**CITY OF PORTLAND, MAINE**  
**PLANNING BOARD**

November 3, 2003

RE: 191 Riverside Street

On October 28, 2003, the Portland Planning Board voted 5 to 0 (Malone abstained, Delogu absent) to approve the site plan for Maine Mall Motors at 191 Riverside Street. The Board voted on the following motions:

N/F  
TIRE WAREHOUSE CENTRAL INC.  
10741/121

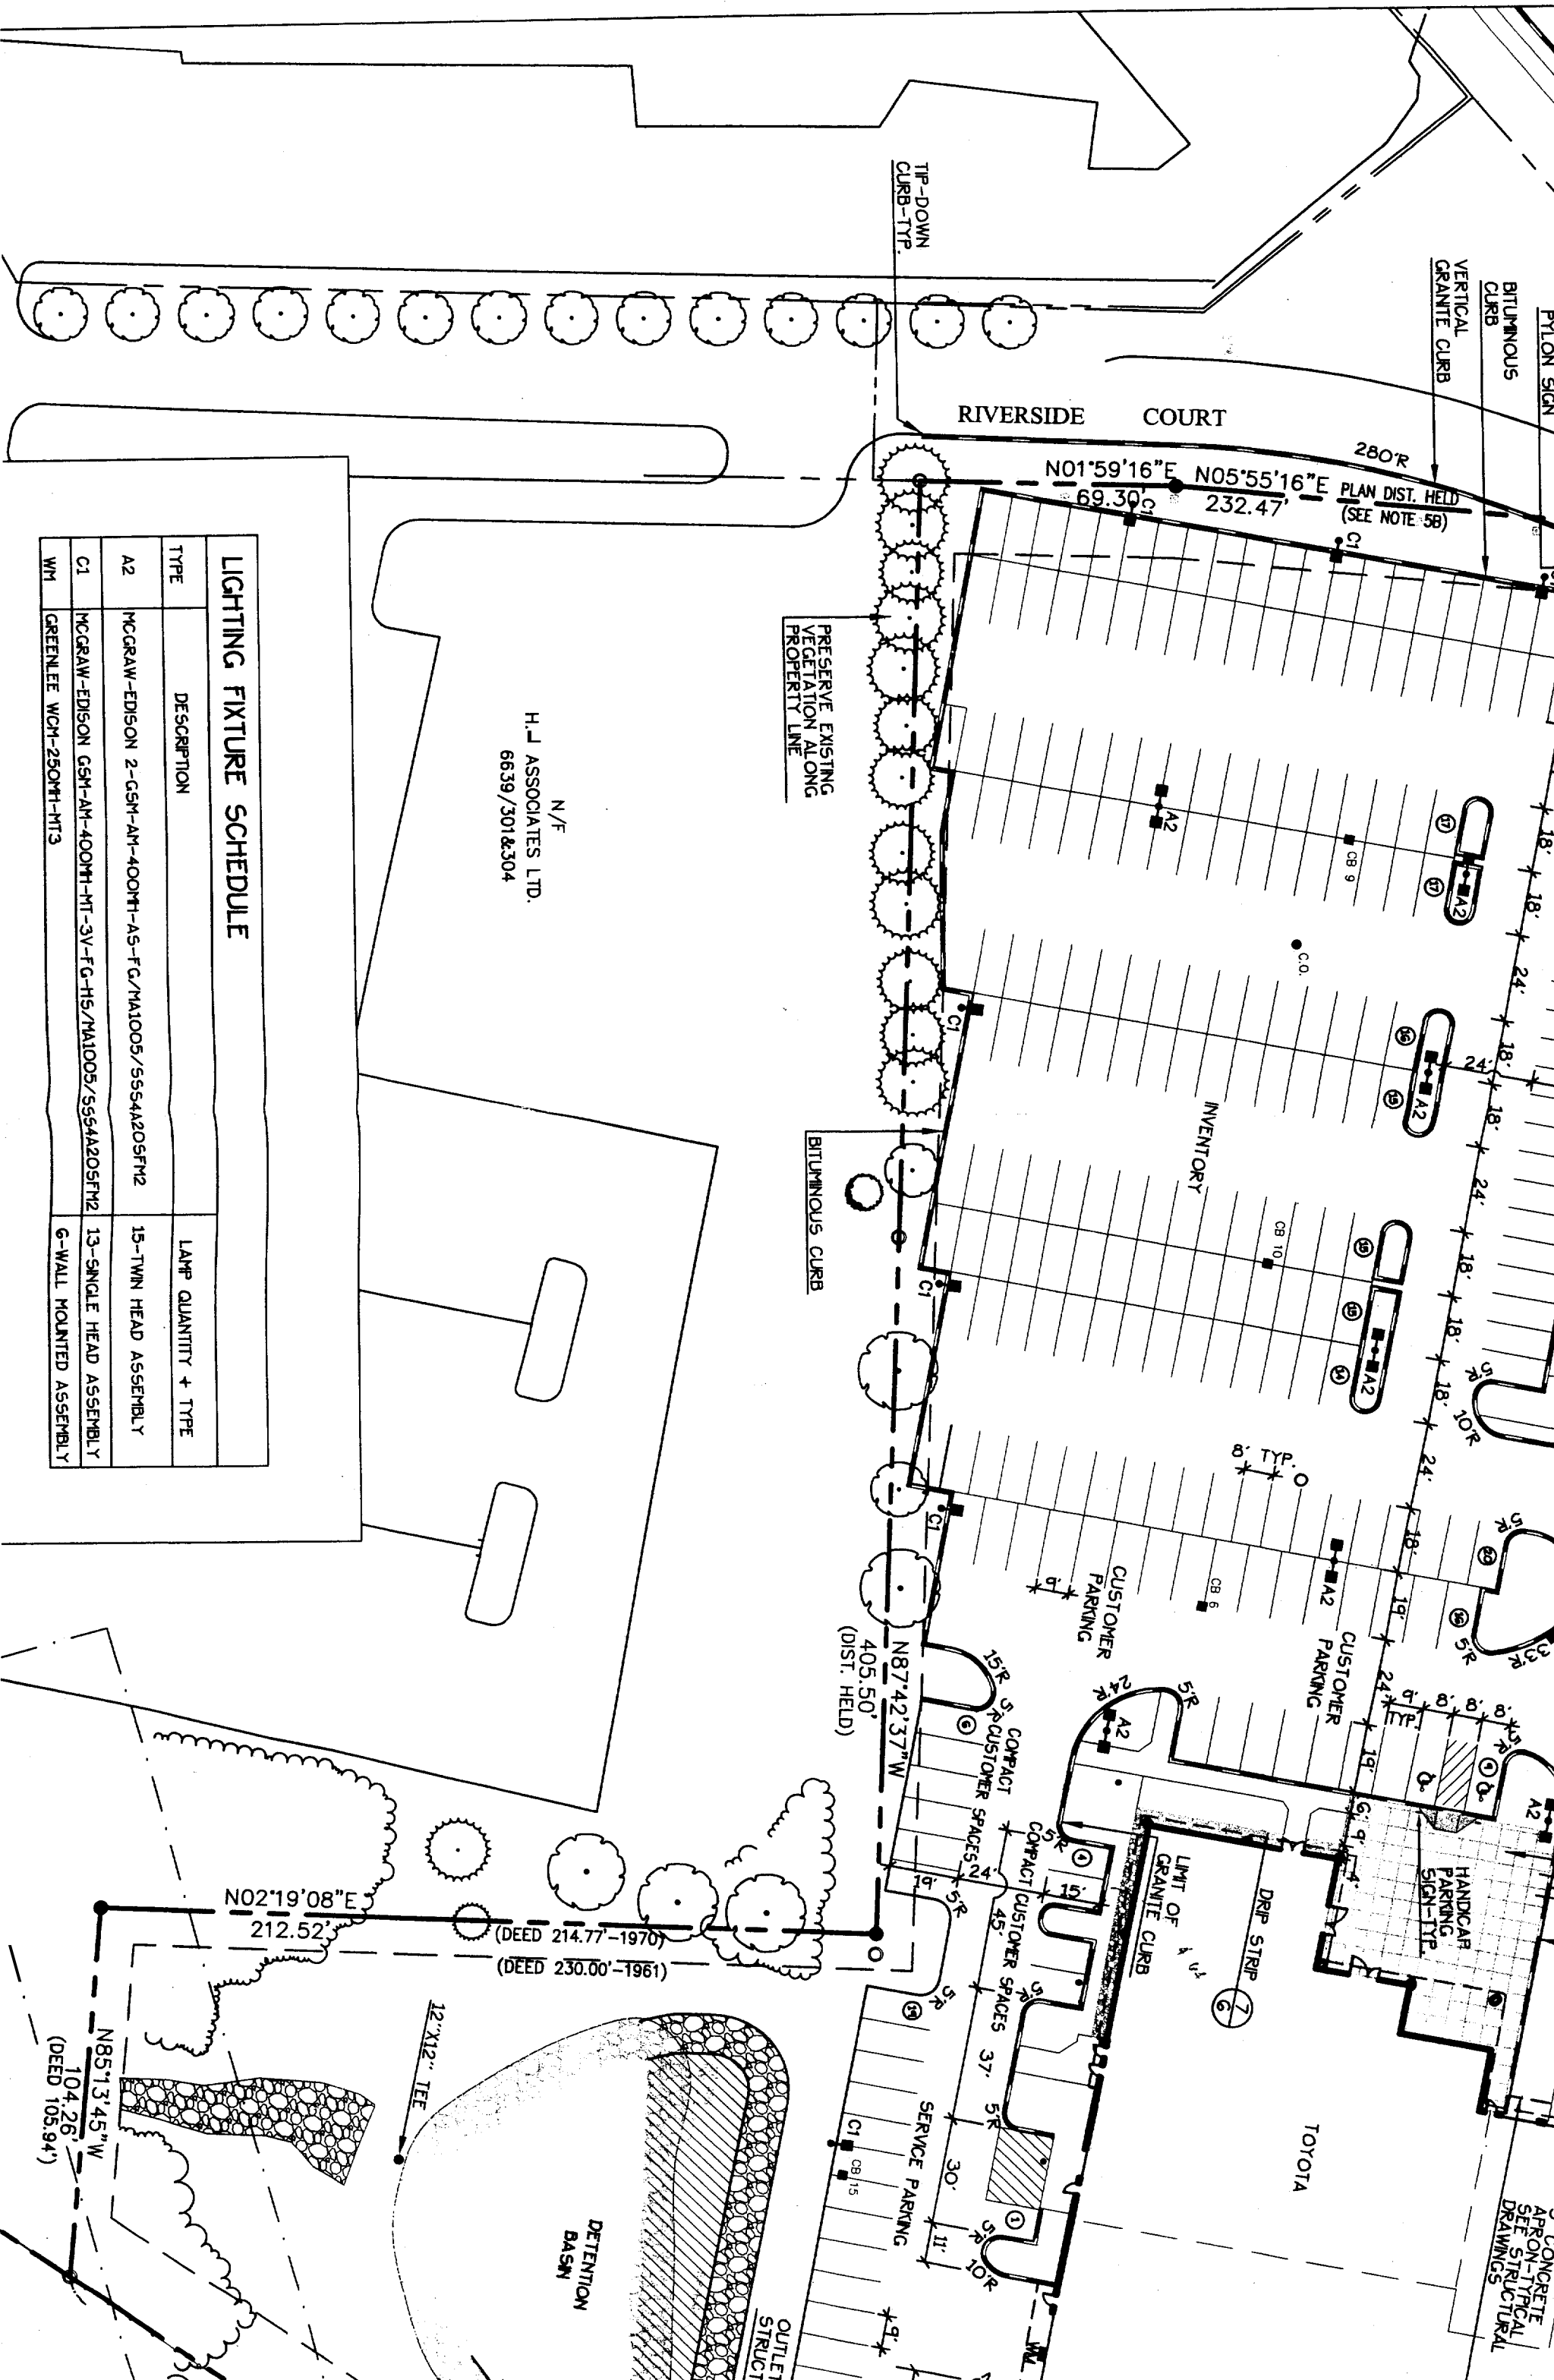
- ii. *That a revised lighting plan be provided for staff review and approval showing reduced light trespass at the property boundaries.*
- iii. *That an easement be provided, subject to the review and approval of City Corporation Council, that allows public access and maintenance of the section of Riverside Court that is proposed to be relocated onto the subject parcel.*
